Case Number ABP-314724-22

Re: Transport Infrastructure Ireland (TII) application to An Bord Pleanála for the Railway (MetroLink-Estuary to Charlemont via Dublin Airport) Order {2022}.

**Property: development known as Shandon Mill, Phibsborough, Dublin 7**

**RESPONSE by Martin O'Malley of O'Malley Associates**  
**on behalf of Shandon Mill Owners Management Company CLG**  
**to TII's RESPONSES to submissions Jan 2024**

Figure 2: Cross Section Through New Surface Platform at Glasnevin

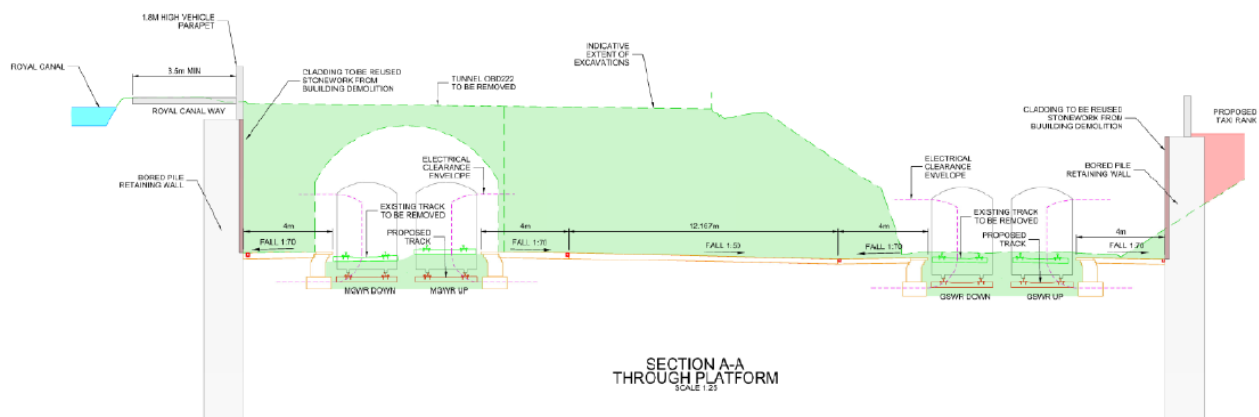
- d. Updated MetroLink Planning Report – updated February 2024.
- e. Outline Legal Submissions On Behalf Of Transport Infrastructure Ireland
- f. TII's: Airborne Rail Noise Effects at Glasnevin during Metrolink Project.pdf  
Page 5: Figure 2: Cross Section Through New Surface Platform at Glasnevin.
- g. The drawings and maps submitted by the Applicant.

There is also the option for the Inspector /ABP to refuse permission for the Irish Rail Inter-change Station, and for the Glasnevin be designated solely as a Metro station. This would reduce the foot print of the station significantly and probably avoid the any temporary closing the North Canal towpath and eliminate the rail line works at the rear of the Cottages. It might also reduce the need to acquire and demolish some of the other properties.

Relocate the MGWR platform position, 100 to 150 metres more towards the west where there is greater separation between the railway line and the canal bank.

Modify the Station design adjacent the Canal to avoid /reduce encroachment towards Canal at pinch point.
